February 8, 1983

RE: DRAINAGE PLAN FOR ALBUQUERQUE NATIONAL BANK OPERATIONS CENTER

J14 - D29

C-1

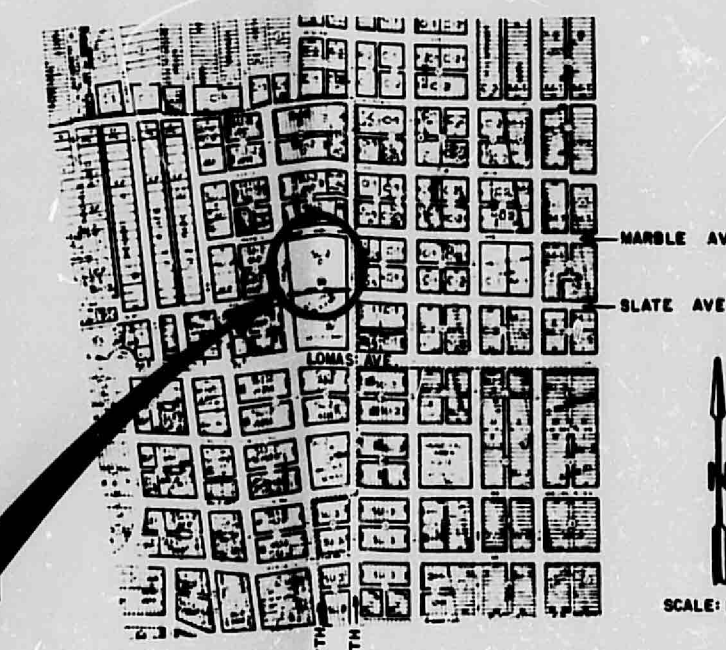
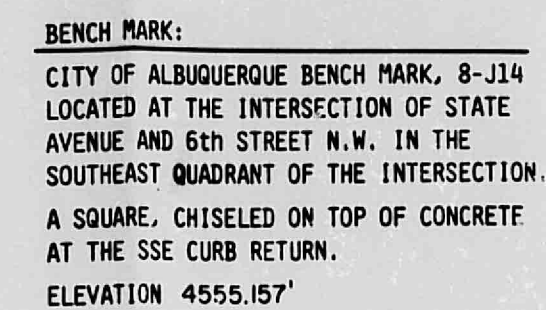
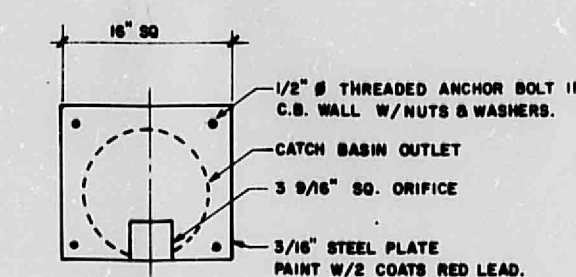
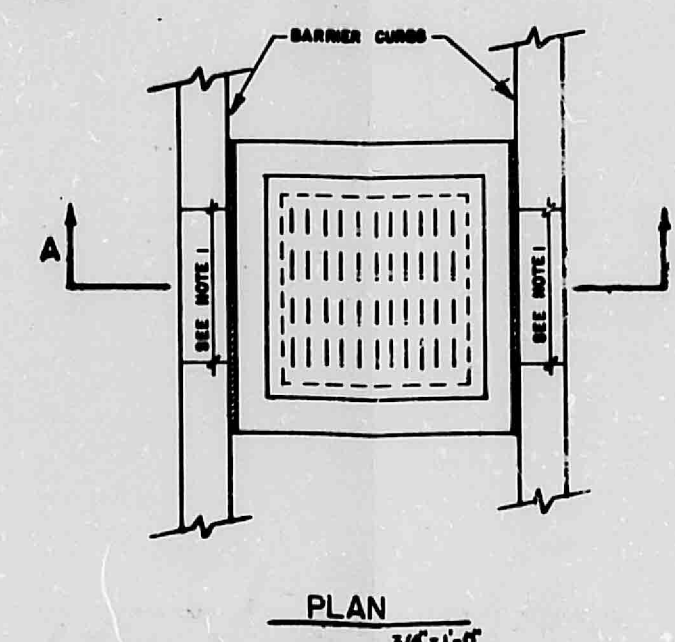
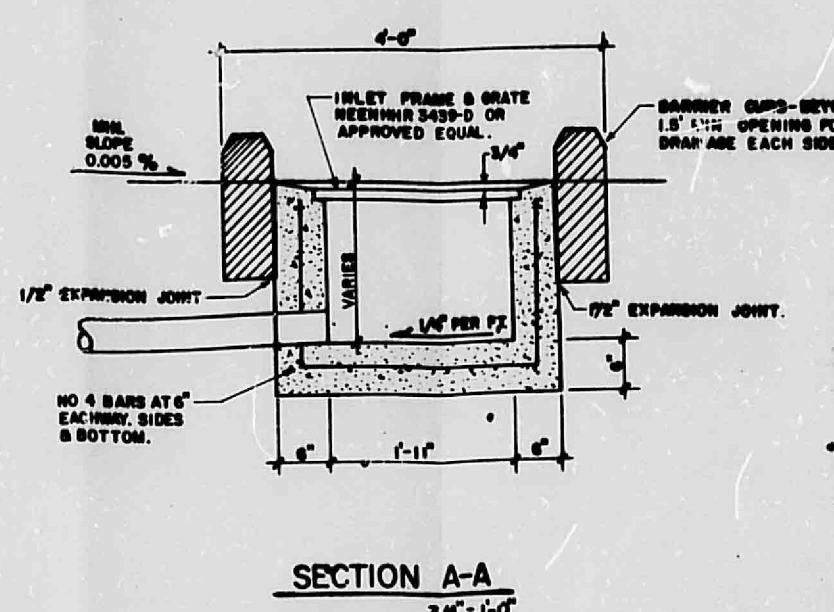
1. Please identify the 100-year ponding limit on the plan.
2. Please call out the orifice plate on Section A-A of the Catch Basin detail.
3. Can the finished floor elevation of the existing building be used as a temporary bench mark?
4. Approved copies of Special Order No. 19 for the storm drain connection must be placed in the City construction sets prior to release of the building permit.

1. The 100-year ponding limit has been identified on the plan.
2. The orifice plate has been called out on Section AA of the catch basin detail. Also, it has been shown to apply only to the southern catch basin.
3. The finished floor elevation of the existing building has been referenced as a temporary bench mark. The south entrance was actually used as a T.B.M.
4. Approved copies of the Special Order No. 19 have been placed in the City construction sets. An approved copy is attached for your information.
